30 May 2014

**PROJECT APPLICATION FOR RESIDENTIAL SUBDIVISION, 'ALTITUDE ASPIRE', AREA E FRASER DRIVE, TERRANORA (MP09\_0166), TWEED LOCAL GOVERNMENT AREA**

NEWLAND DEVELOPERS PTY LTD	09-374 24-02-2012
TERRANORA PRECINCT 1 ROAD 1 - FRASER DRV. INTERSECTION LAYOUT	SK 3646 REVISION A

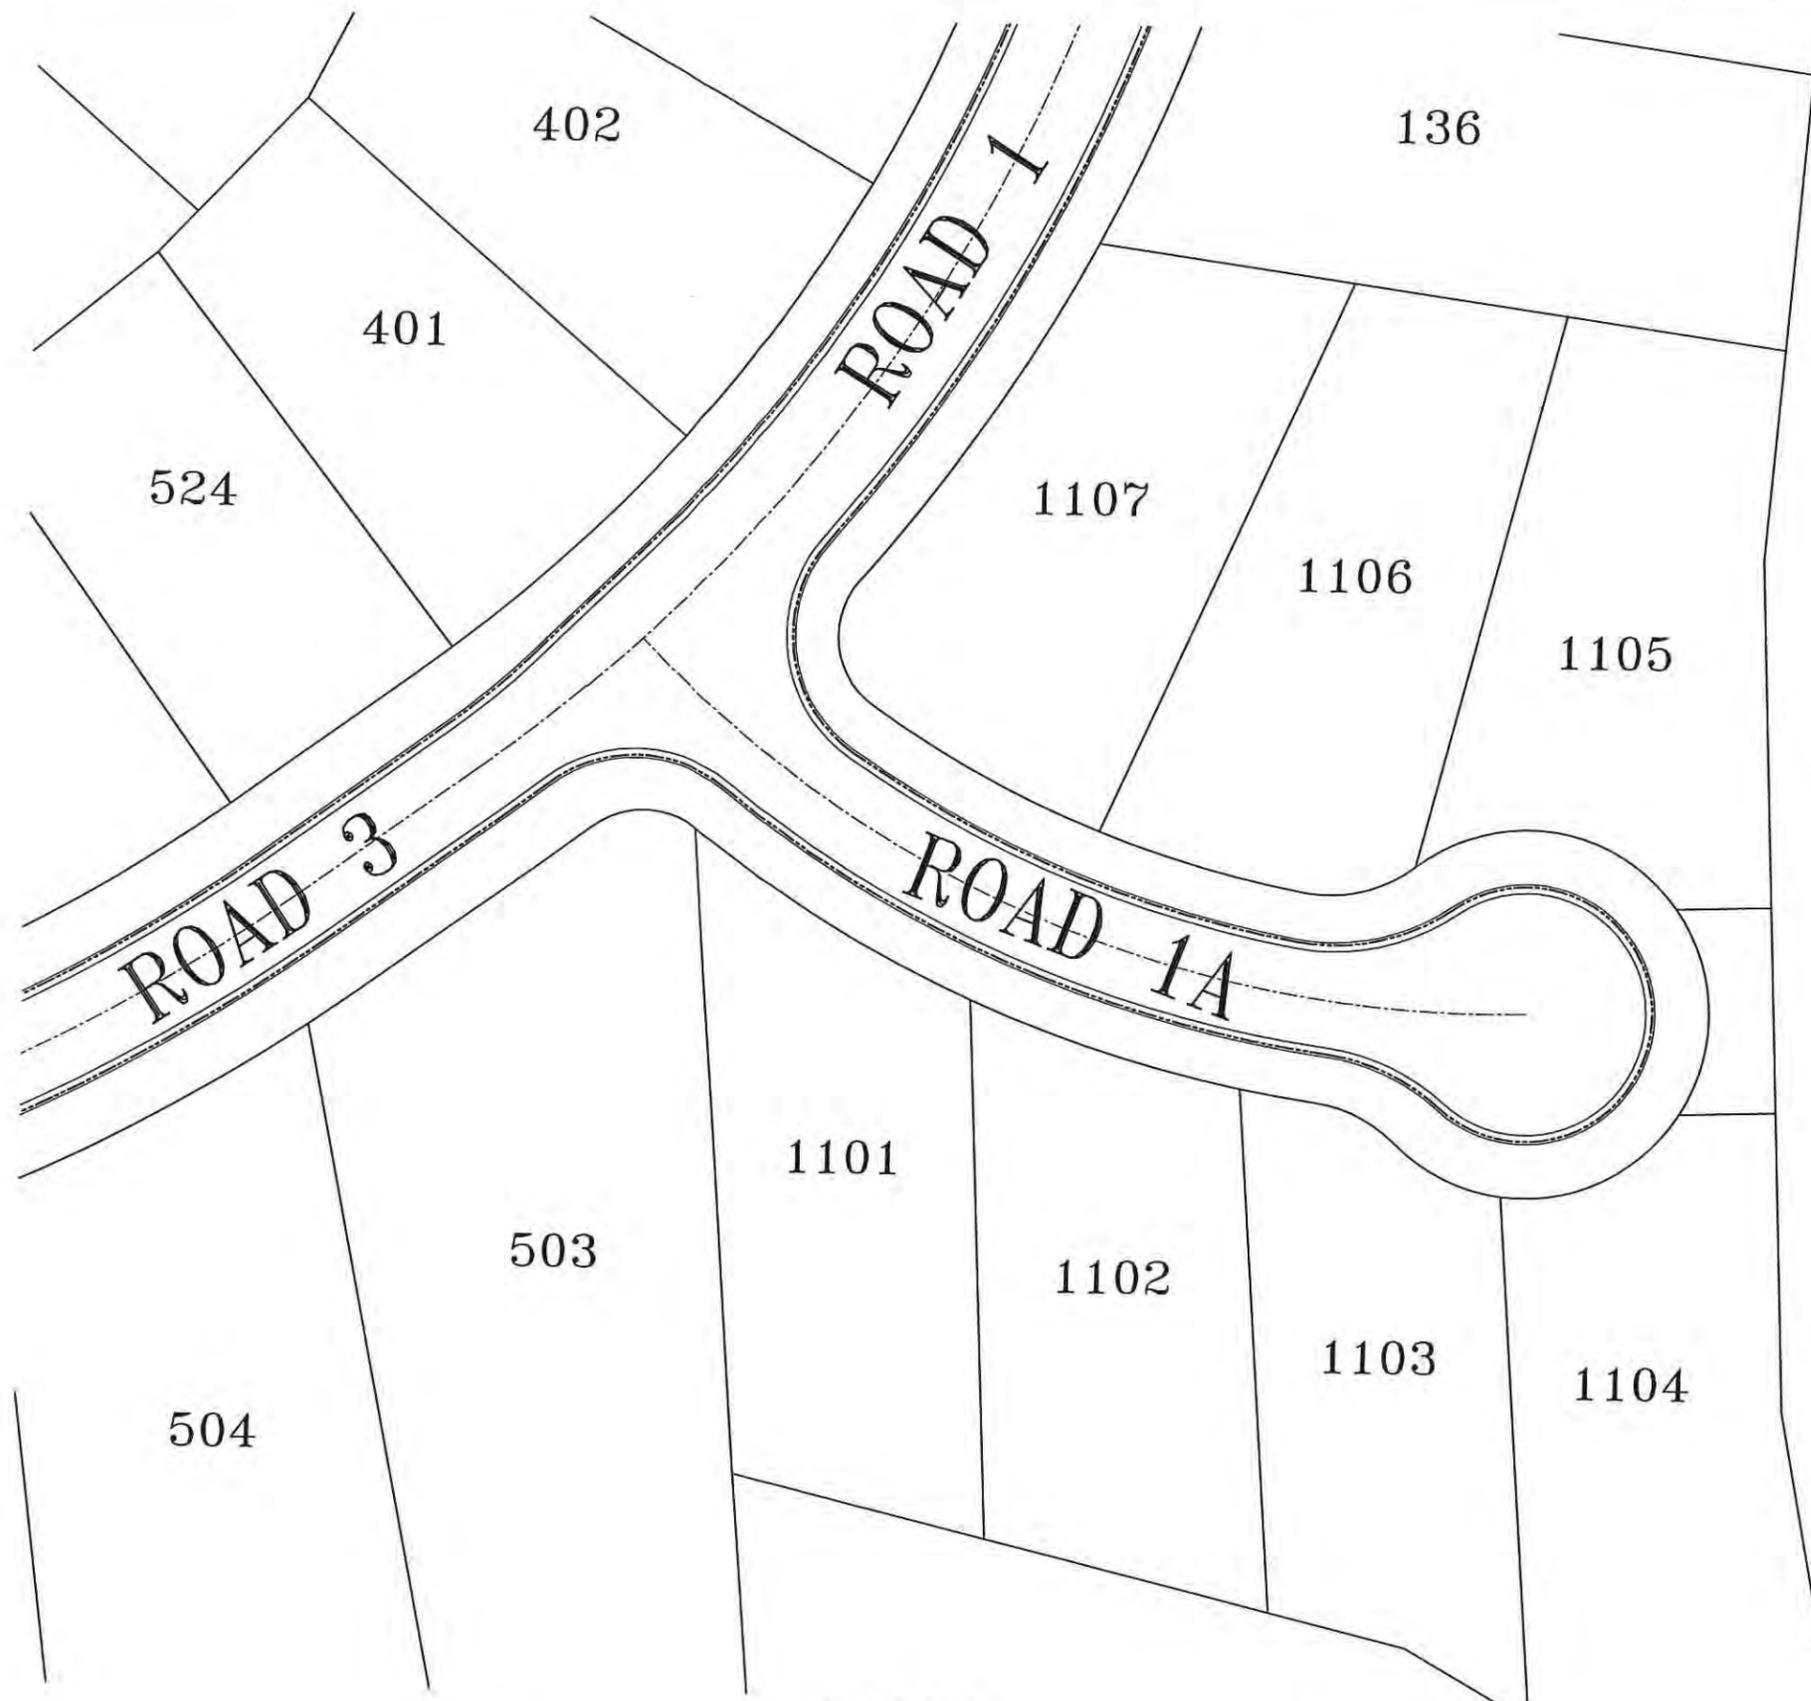
- Intersection of Fraser Drive and Proposed Road No 1 – Given concerns expressed that the proposed intersection of Frasers Drive and proposed Road No 1 may adversely impact on driveways to existing residences on the eastern side of Fraser Drive, the Department has suggested that Condition B39 be amended to retain existing vehicular access arrangements for affected residential properties.

In relation to the intersection of Fraser Drive and proposed Road No 1, the Commission notes the potential for this intersection to adversely impact on the driveways to existing residences on the eastern side of Fraser Drive. Condition B39 (now B43) is therefore amended to address this concern.
